Application for a non-material amendment following a grant of planning permission.

Number	28
Suffix	
Property name	
Address line 1	North Lane
Address line 2	
Address line 3	
Town/city	East Preston
Postcode	BN16 1DA
Description of site location must be completed if postcode is not known:	
Easting (x)	507617
Northing (y)	102735
Description

Two storey side & single storey rear extensions.

Reference number: EP/156/17/HH

28 NORTH LANE, EAST PRESTON
Proposals 03 b Nov 2017

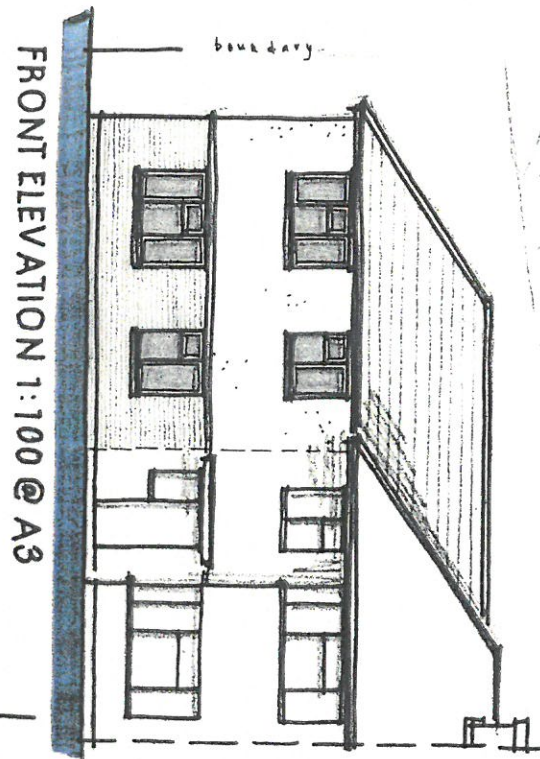
We would like to come out 1000mm more on the single storey kitchen extension. This taking it from 4050mm to 5050mm.
